COMMUNITY DEVELOPMENT DEPARTMENT
80 Columbia Avenue ♦ Marysville, WA 98270
(360) 363-8100 ♦ (360) 651-5099 FAX

Re: Maryville Corporate Center – *Technical Review 2*
PA 22004

PRELIMINARY BSP COMMENTS

DRAWN BY: L. Nguyen	CHECKED BY: S. Woods
DATE: AUG 11, 2022	JOB NAME: 20-195
SCALE: N/A	JOB NO.: 20-195B

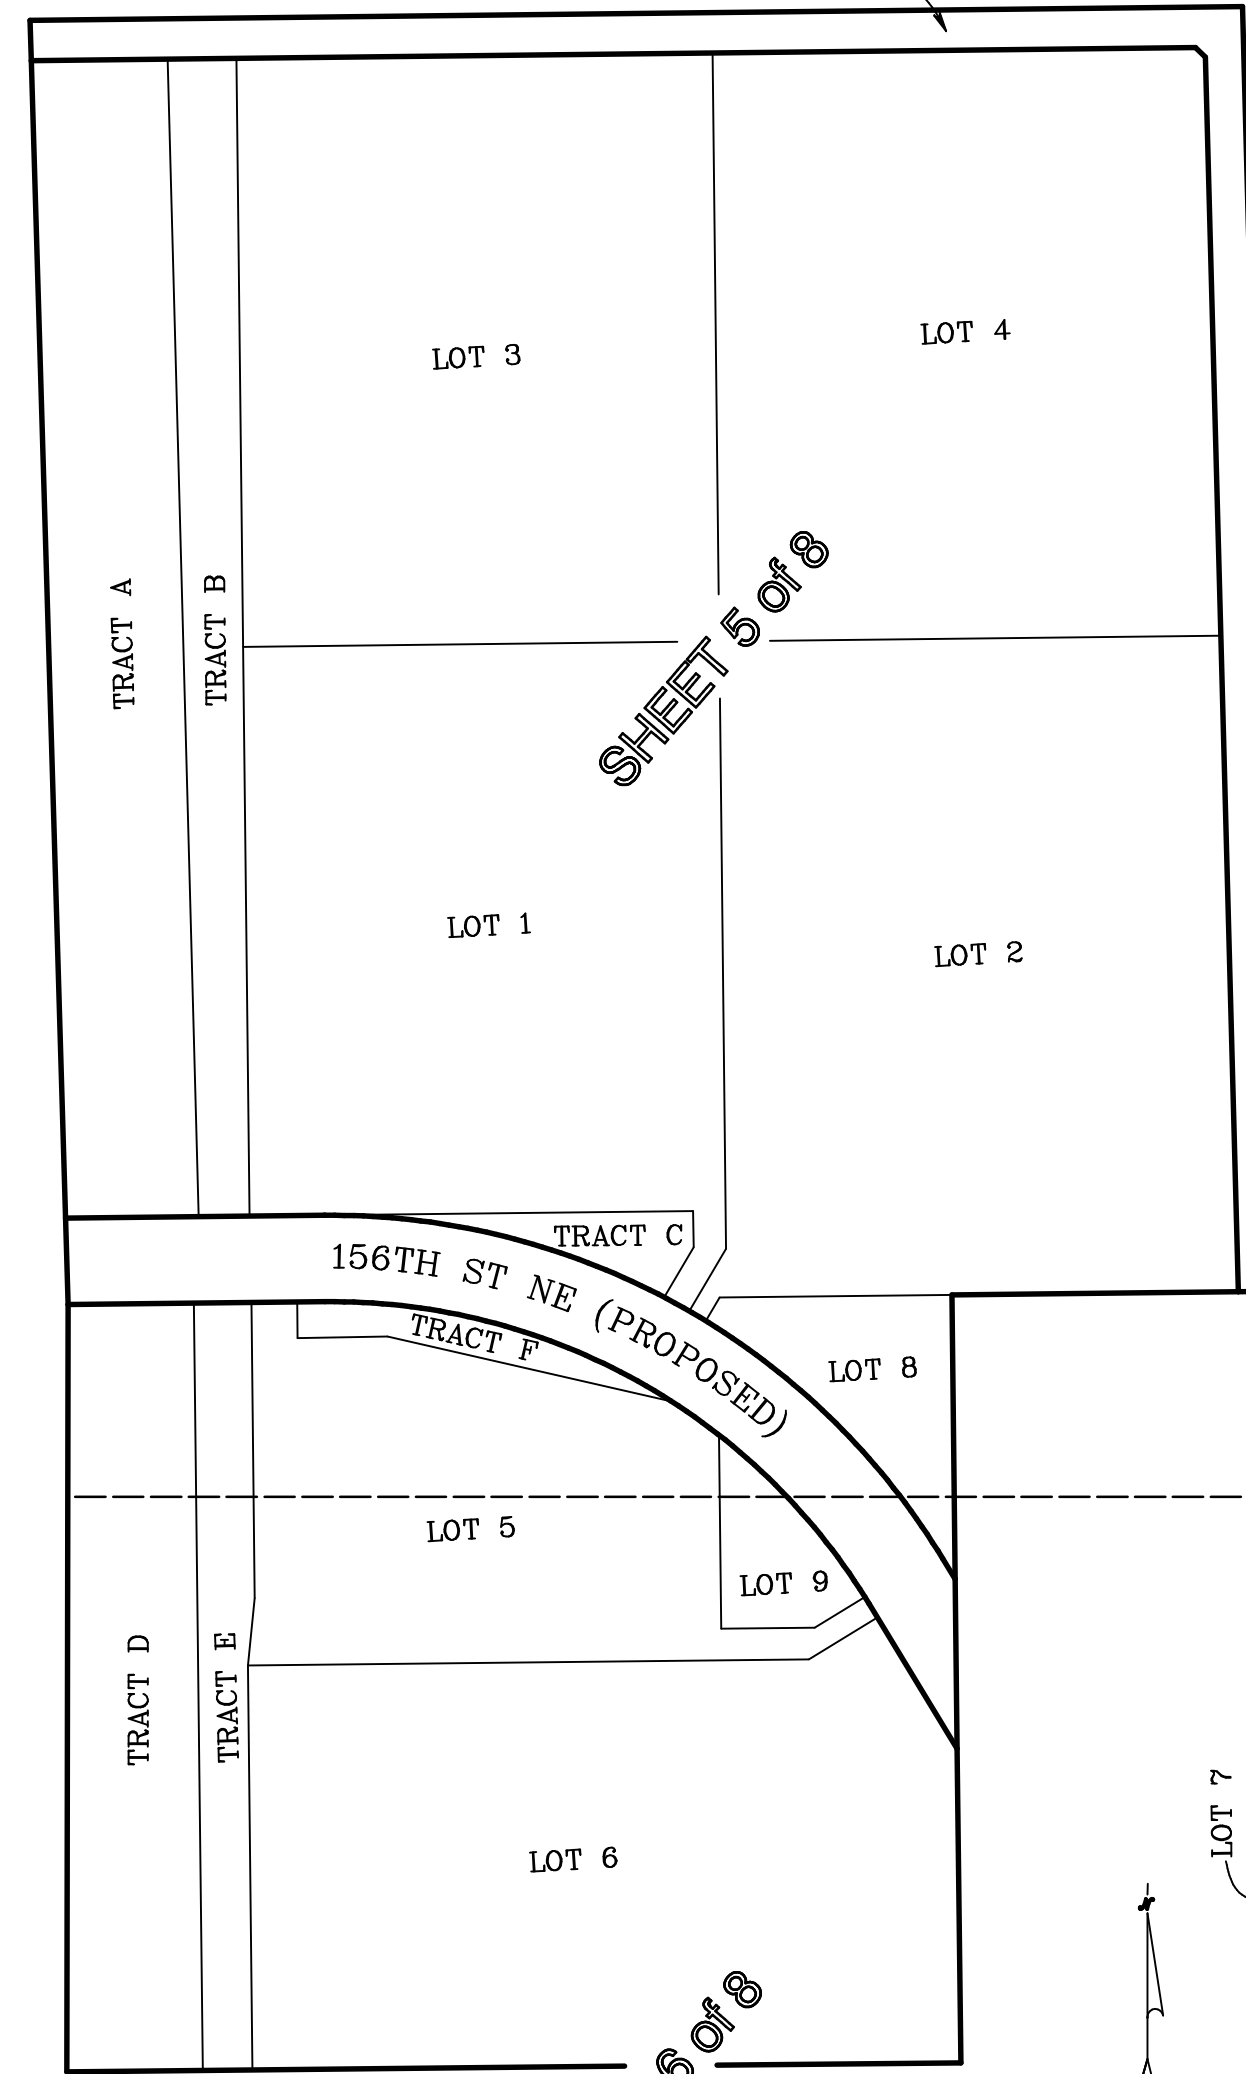
- j. Remove "A.F. NO. _____" from all sheets.
- k. Remove DECLARATION, ACKNOWLEDGEMENTS, CITY ENGINEER APPROVAL, COMMUNITY DEVELOPMENT APPROVAL, MAYOR APPROVAL, RECORDING CERTIFICATE, TREASURER'S CERTIFICATE AND LAND SURVEYOR'S CERTIFICATE and language from Sheet 1 of 8. This information is only required on the FINAL BSP to be recorded.

Additionally, remove "SHEET 5 OF 8" and "SHEET 6 OF 8" from Sheet 1. These are not correct references and are not needed.

INDEX DATA: SEC 28-33 T 31N R 5E WM
SURVEY FOR: PACIFIC REALTY ASSOCIATES, L.P. 15908 47TH AVE NE MARYSVILLE, WA 98271
SNOHOMISH COUNTY, WASHINGTON
SHEET 2 OF 8

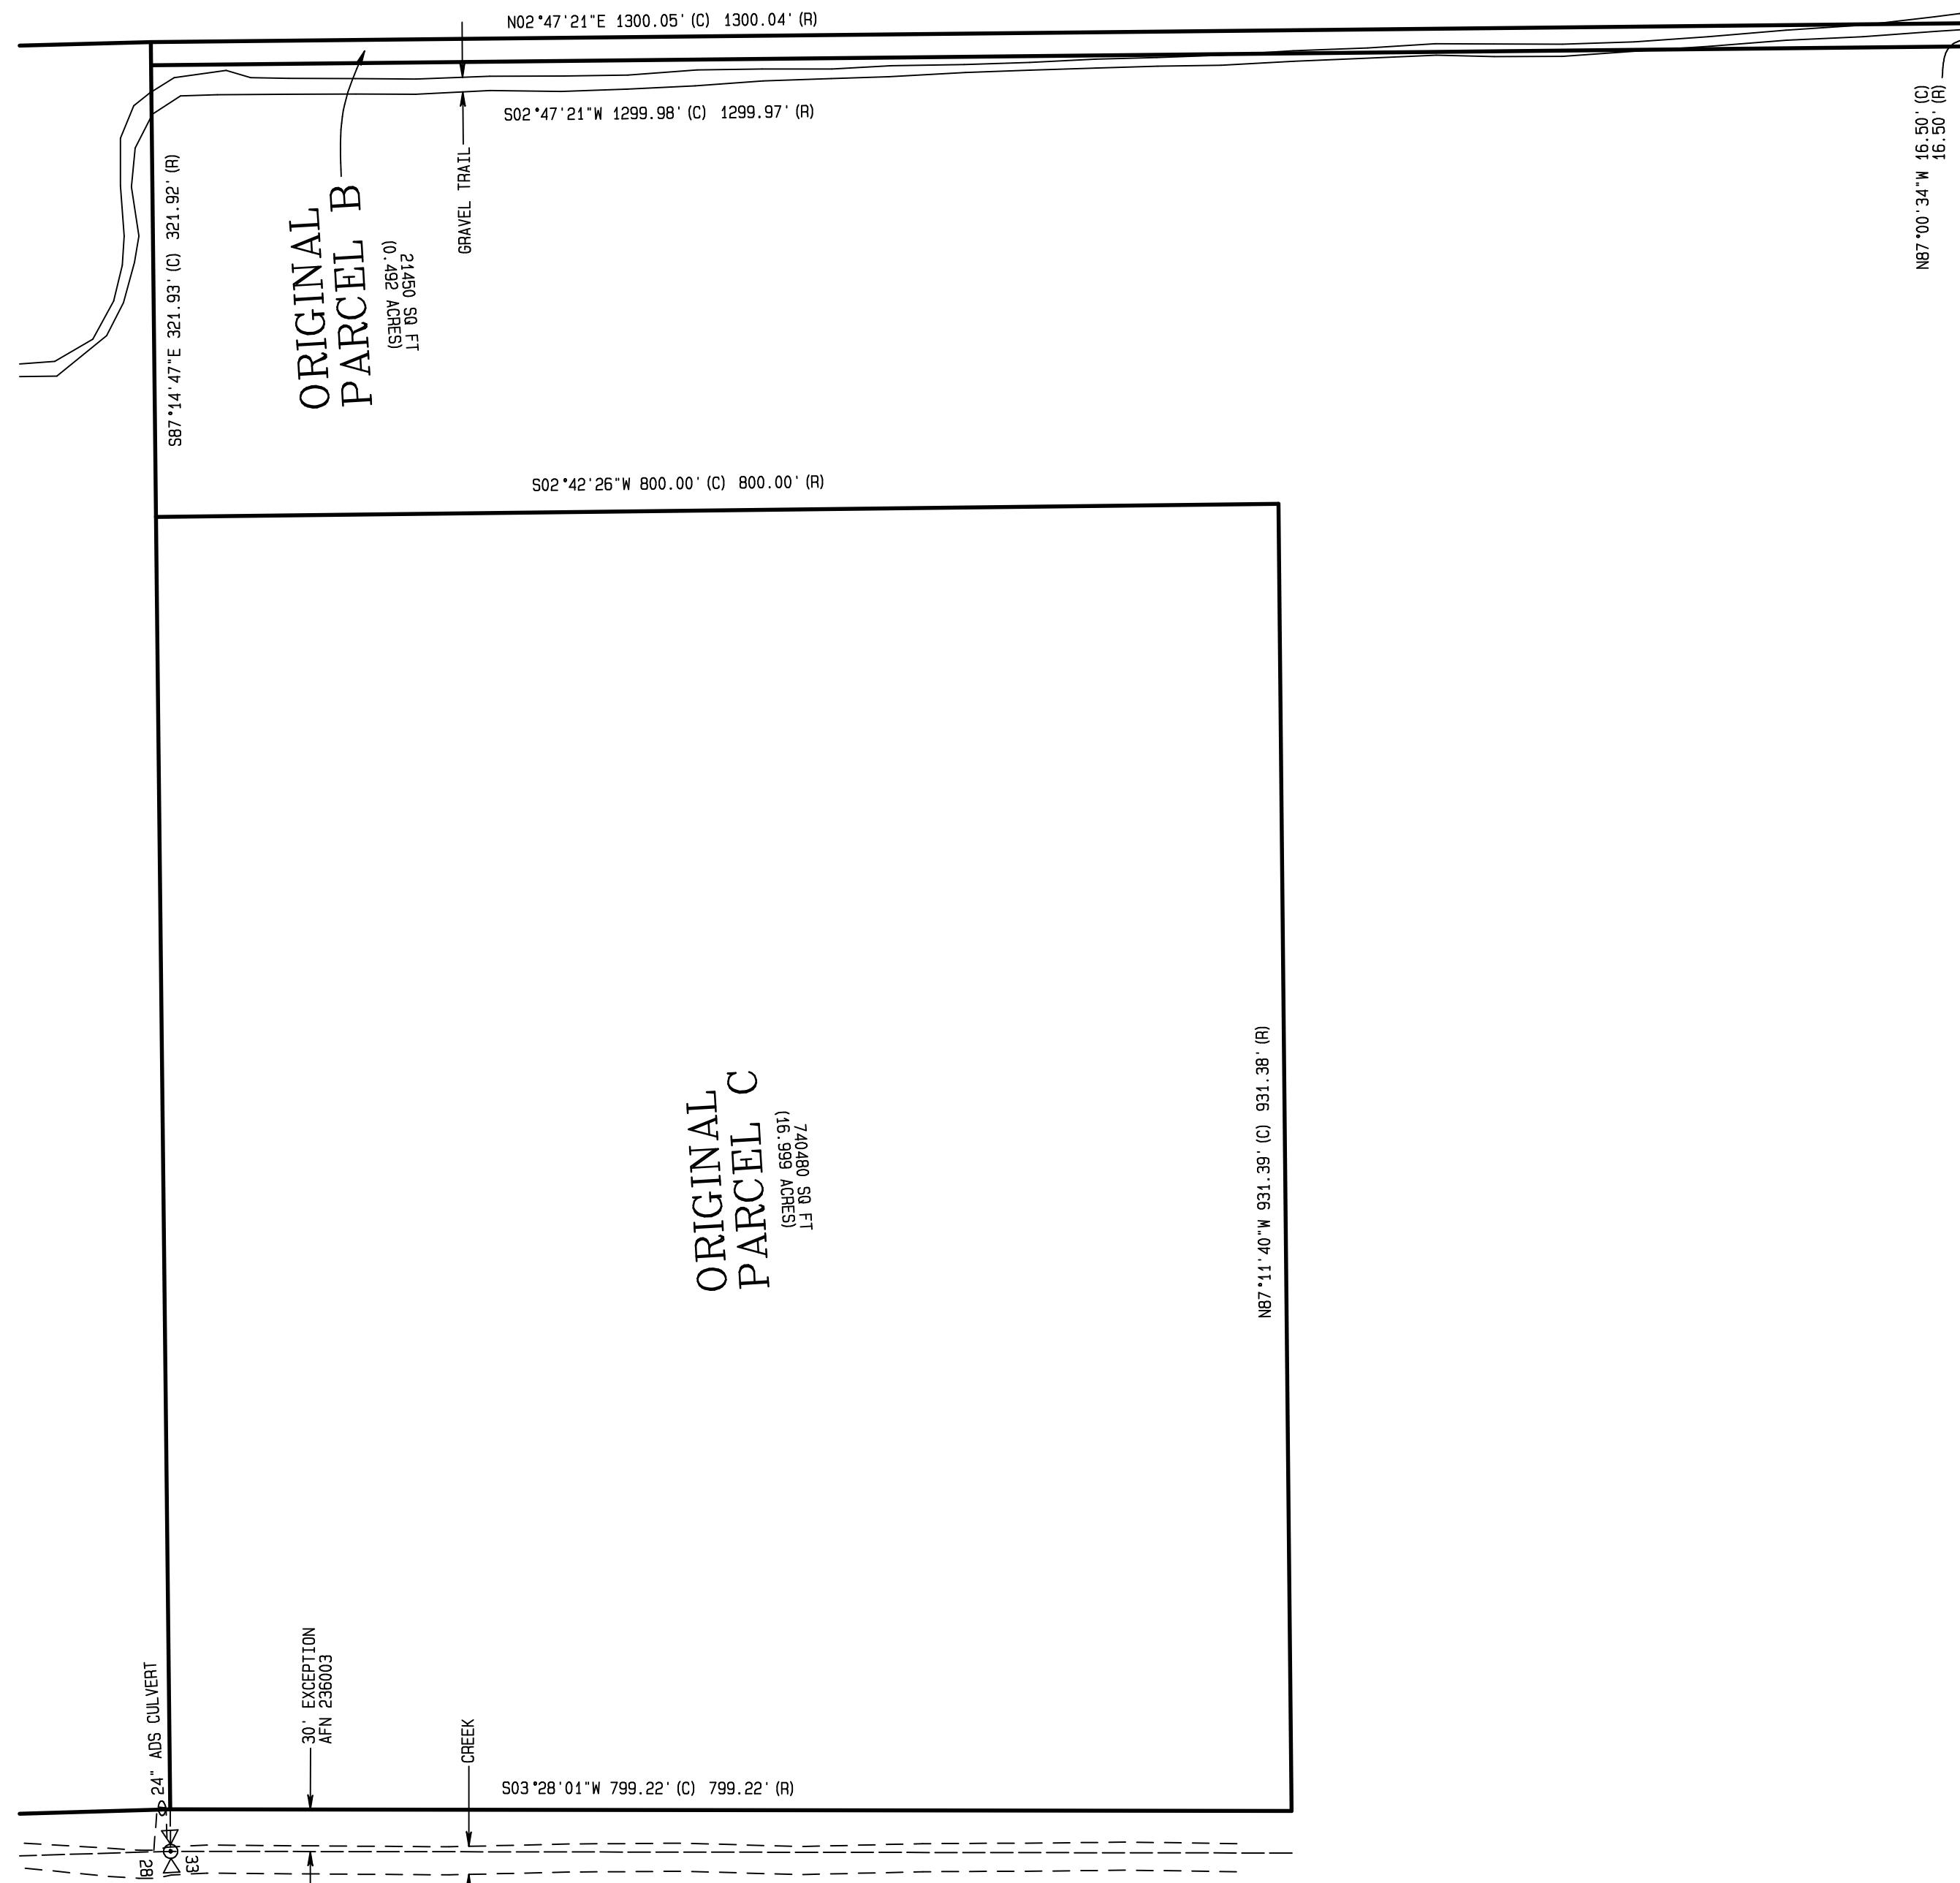
Applicant's Response: Parking compliance is shown on sheet 2 of 6 for the entire BSPE.

TR2 Comments: Provide the math for the required parking (including standard, carpool, ADA and bicycle), a detail of carpool parking signage, required parking stall dimensional standards, turning radii and auto turn as noted in the TR1 comments.

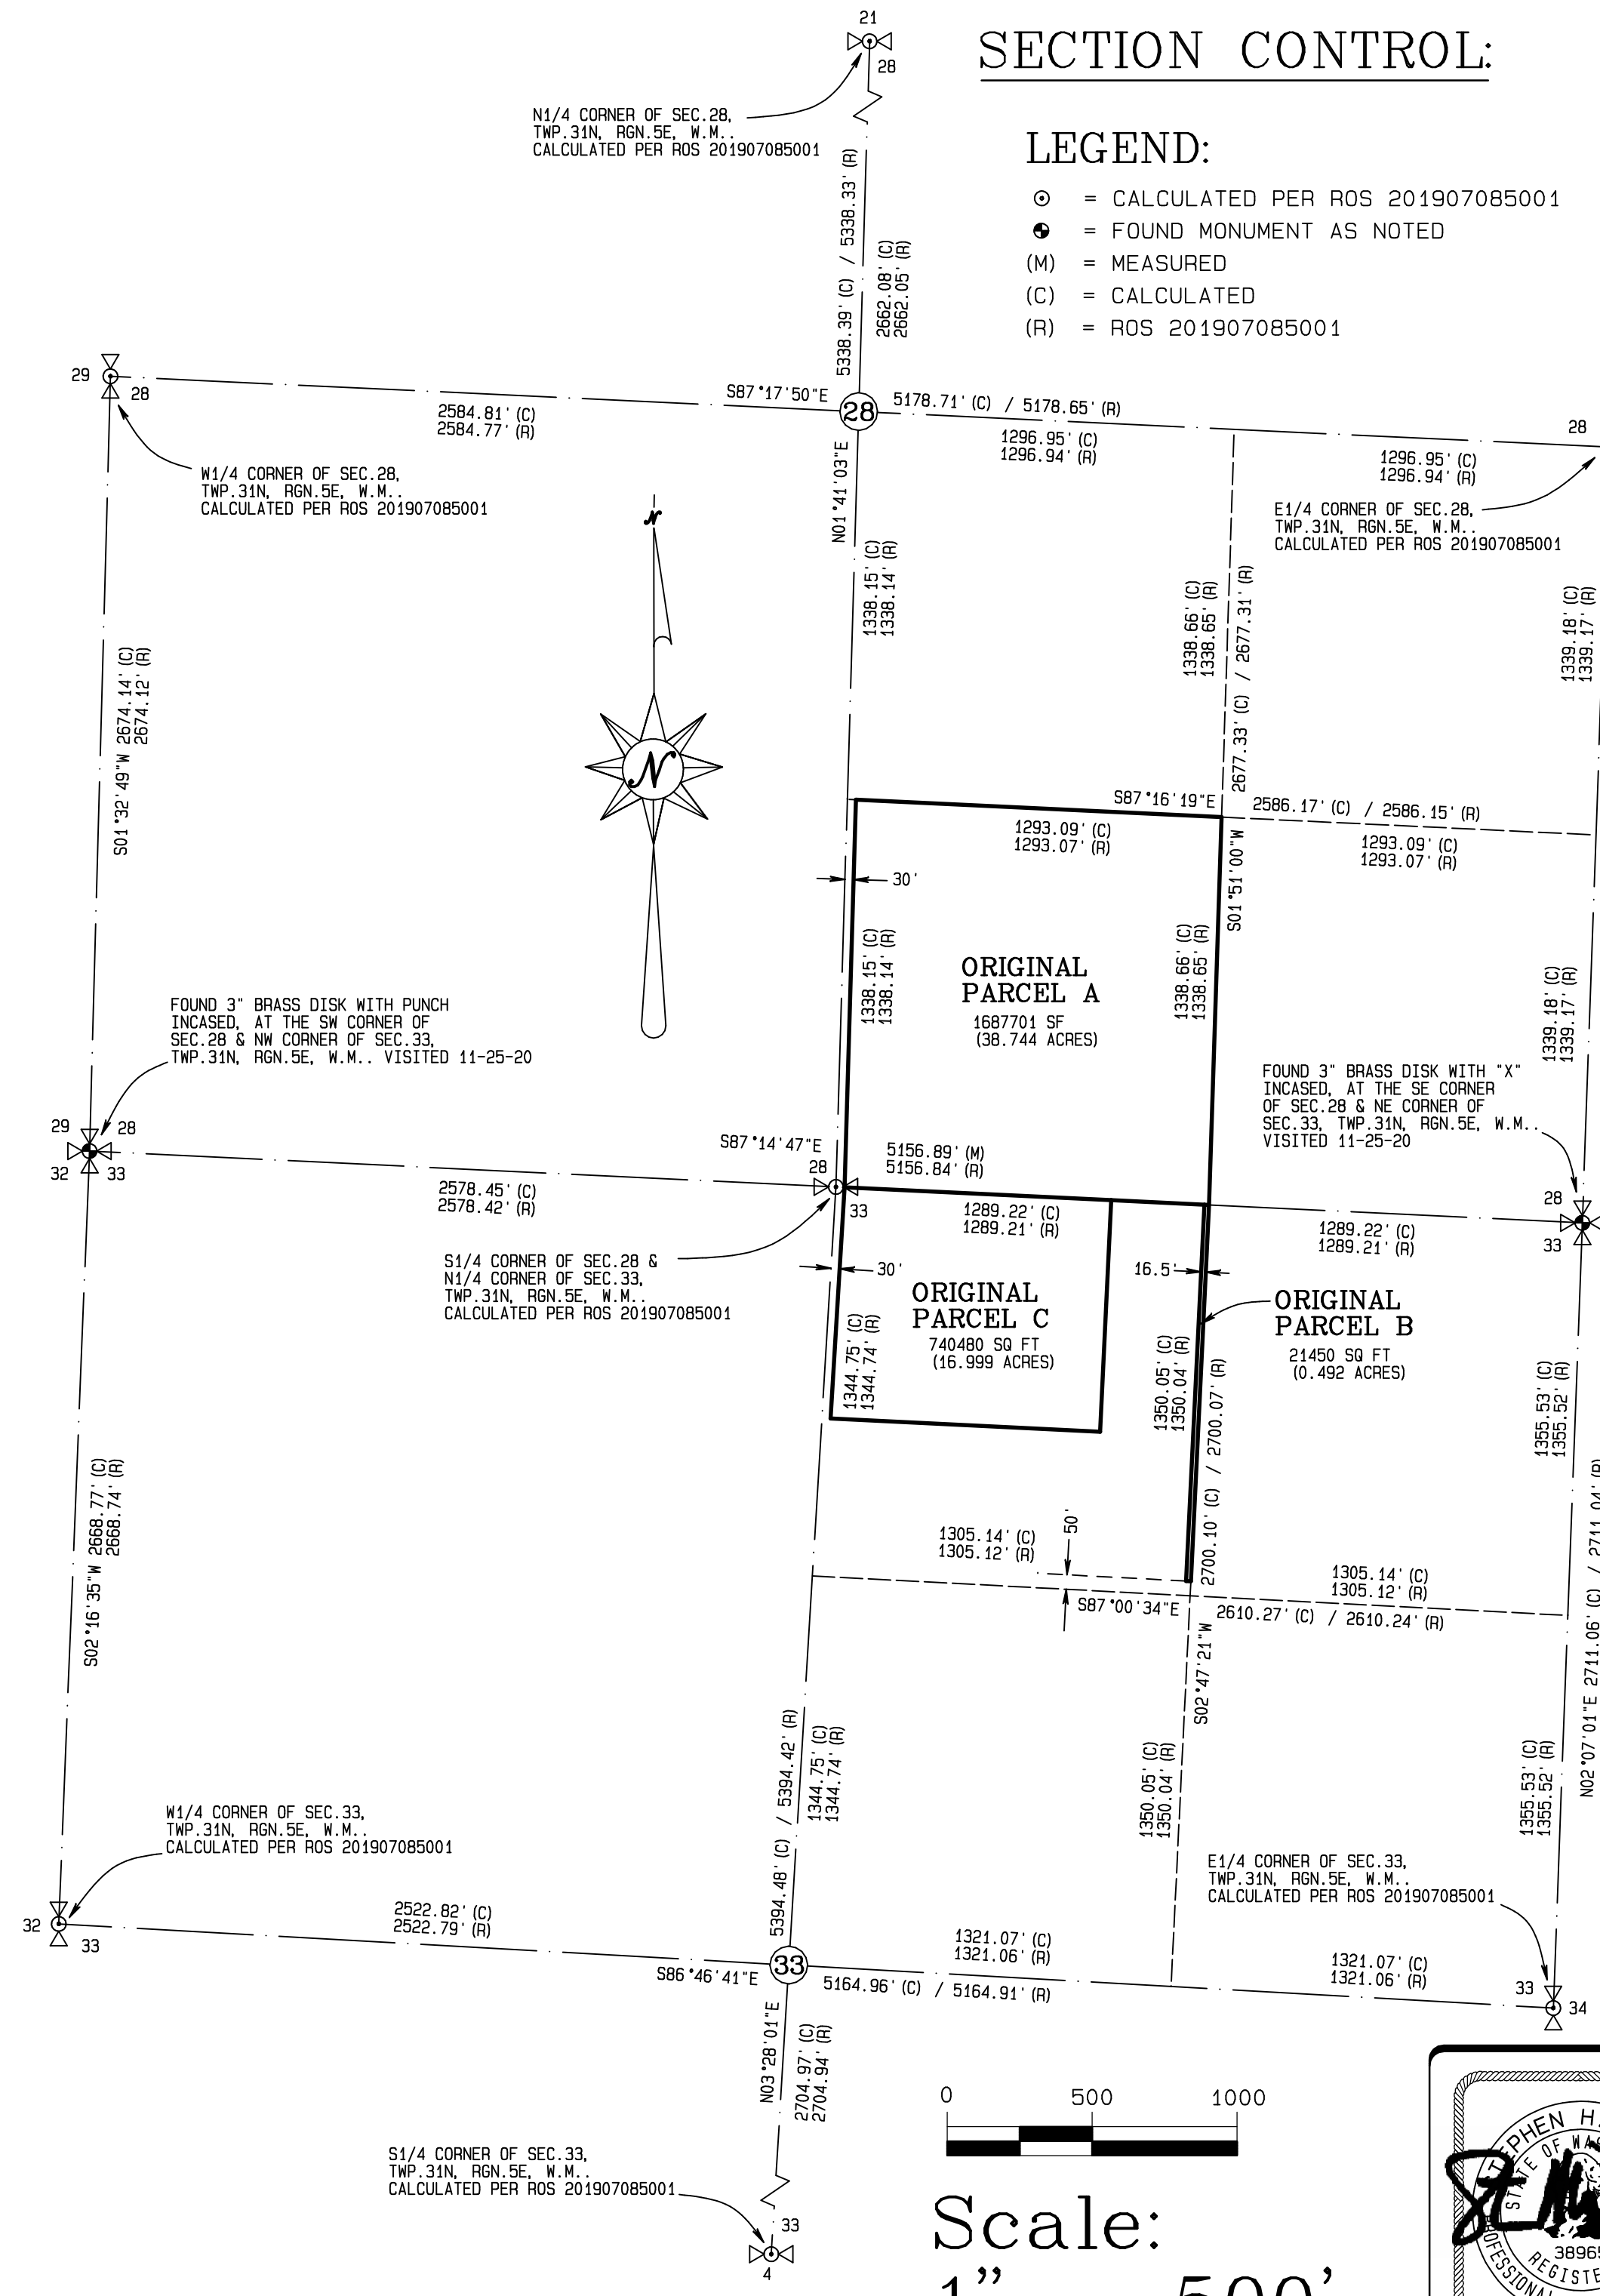
Applicant's Response: As shown on sheet 4 of 6, Phase 1 is a draft solid line and future phases are shown as a greyed out line. We understand future phases will require individual site plan review.

TR2 Comment: Phase lines have not been identified on any of the sheets. Sheet 4 of 8 includes zoning compliance information.

- l. Provide a Table that identifies each TRACT the SF and proposed Use of the TRACTS.
- m. Sheet 4 of 8 includes a "ZONING COMPLIANCE - TOTAL PHASE" section. Confused what this information is representing? Compliance with the LI bulk & dimensional standards as outlined in [MMC 22C.020.080\(2\)](#) is required. What is "Landscape Area," "Sidewalk/Drive Aisle Area" and "Building Area," and what Phase is it for? The setbacks noted are incorrect, the base height allowance is not noted and the math for the maximum impervious surface is not provided. Please amend and provide the additional information noted.
